Thank you for consulting us regarding this discharge of conditions application. We have the following comments regarding condition 3.

Application No: M/130/21/DOC
Registered: 4th October 2021
Site Address: 8 Manor Way Elmer Middleton-On-Sea PO22 6LA
Description of Works: Approval of details reserved by condition imposed under ref M/86/20/PL relating to Condition No 3 - surface water drainage.

REAR GARDEN GROUND FLOOR TERRACE
CONSTRUCTION PERMEABLE BLOCK PAVING
(Scale 1:20)

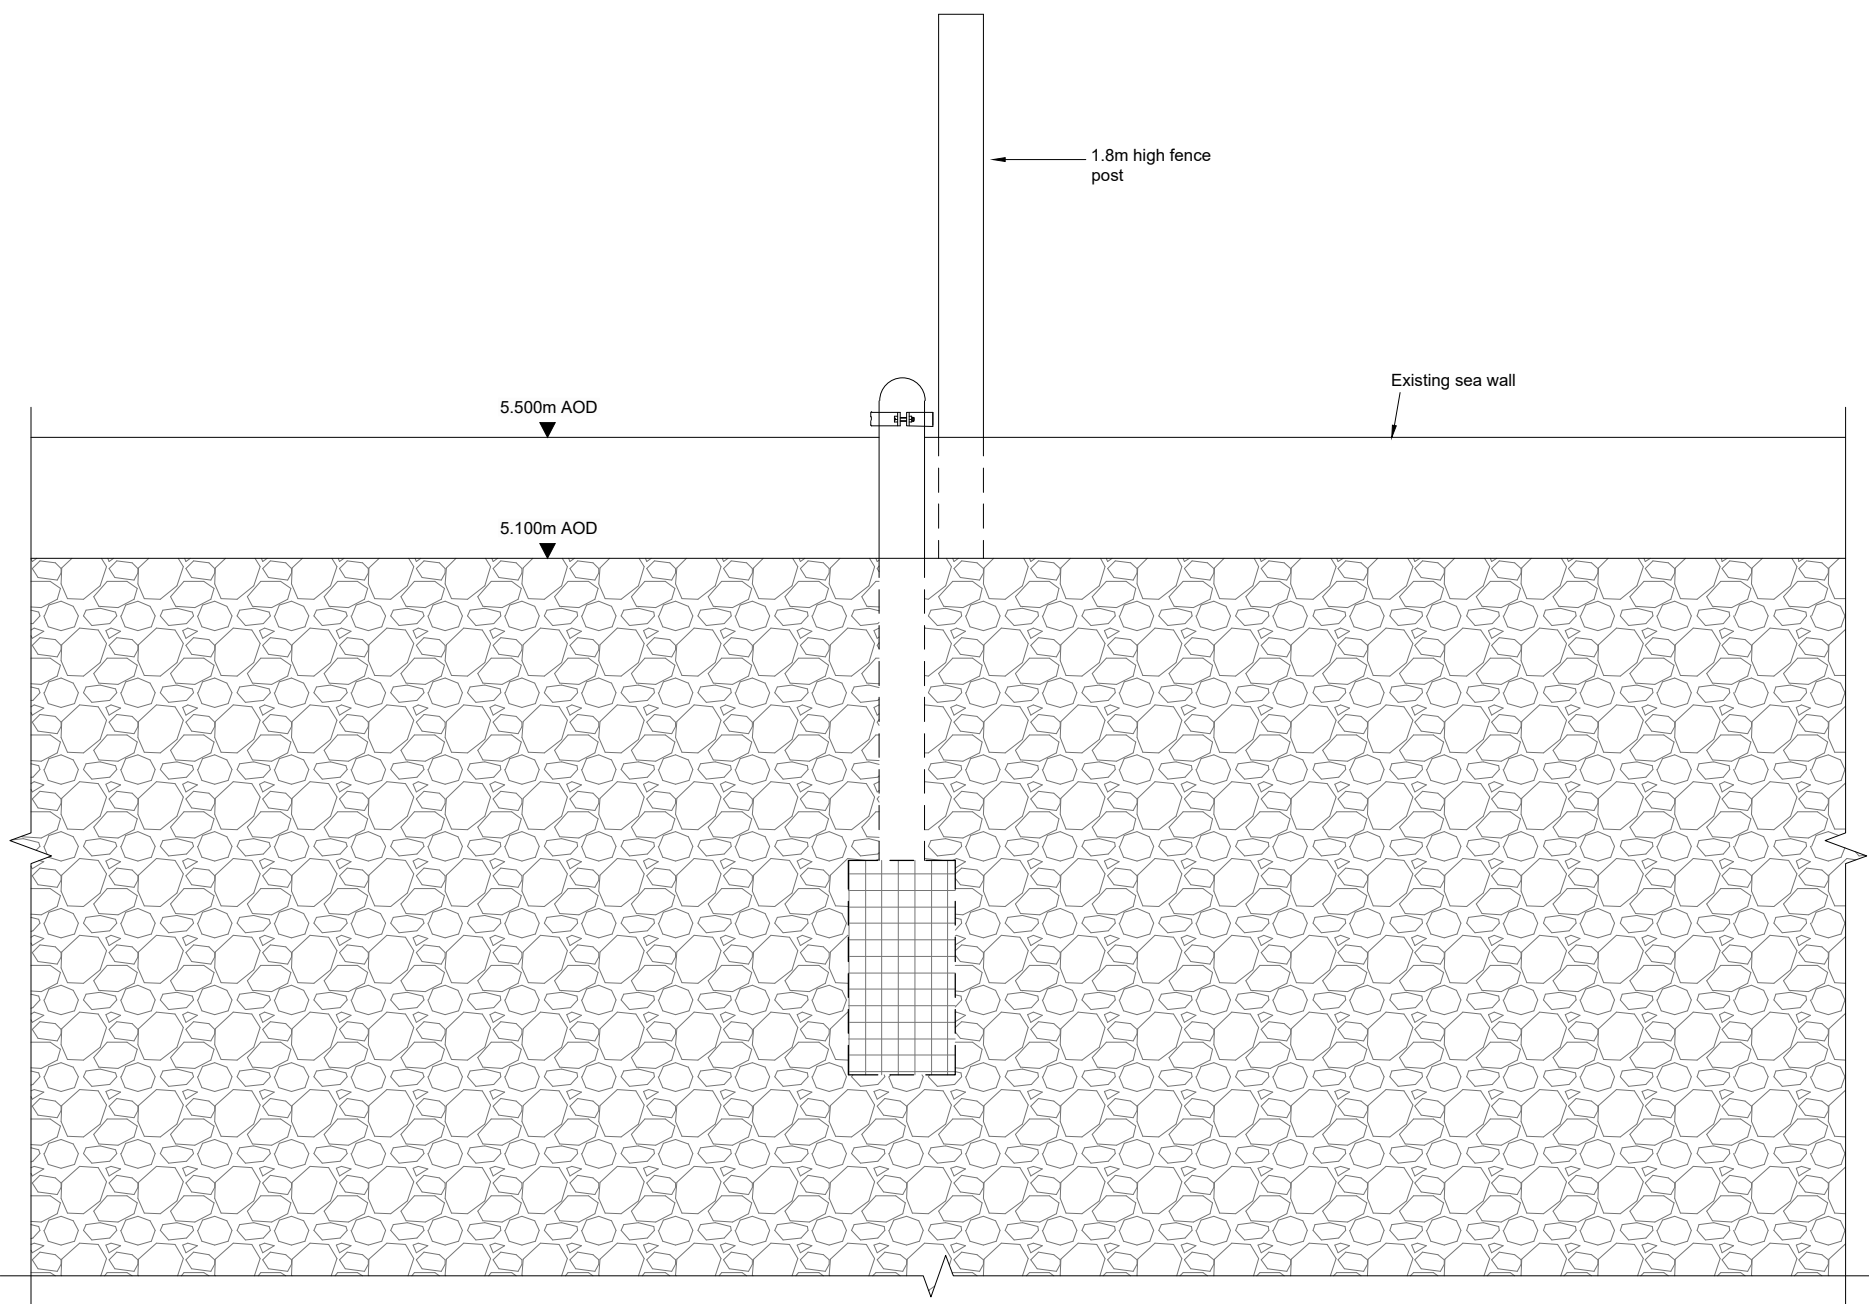
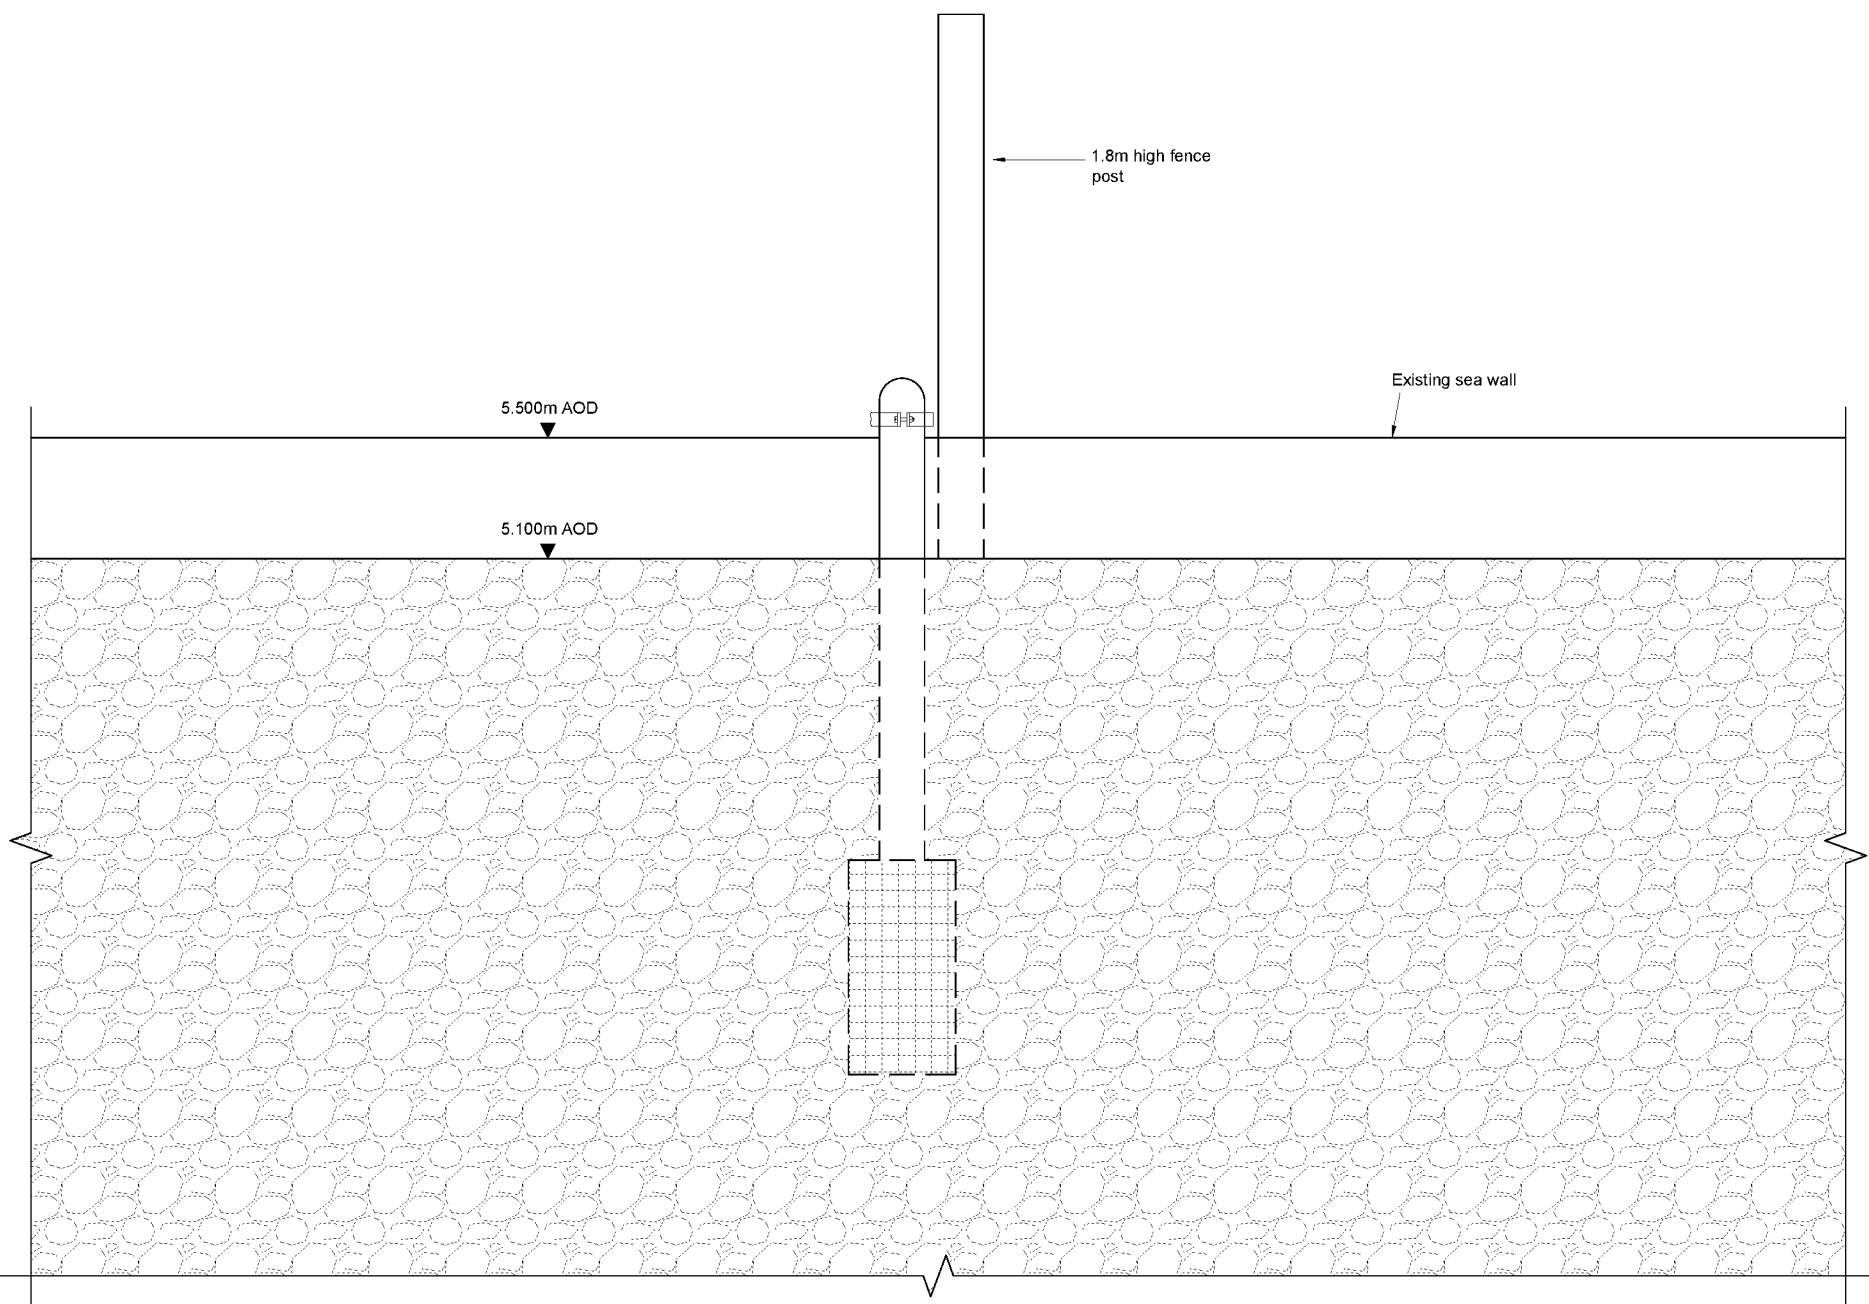
Please can an impermeable liner be provided to the sides of the rear garden ground floor terrace to ensure that water does not travel through the sides of this raised area and infiltrates through the bottom only.

Further to Laura's comment we have added an impermeable membrane to the sides of the rear garden terrace area on drawings 201A and 501A, copies attached. I trust this will allow the surface water scheme and Planning Condition 3 to be discharged.
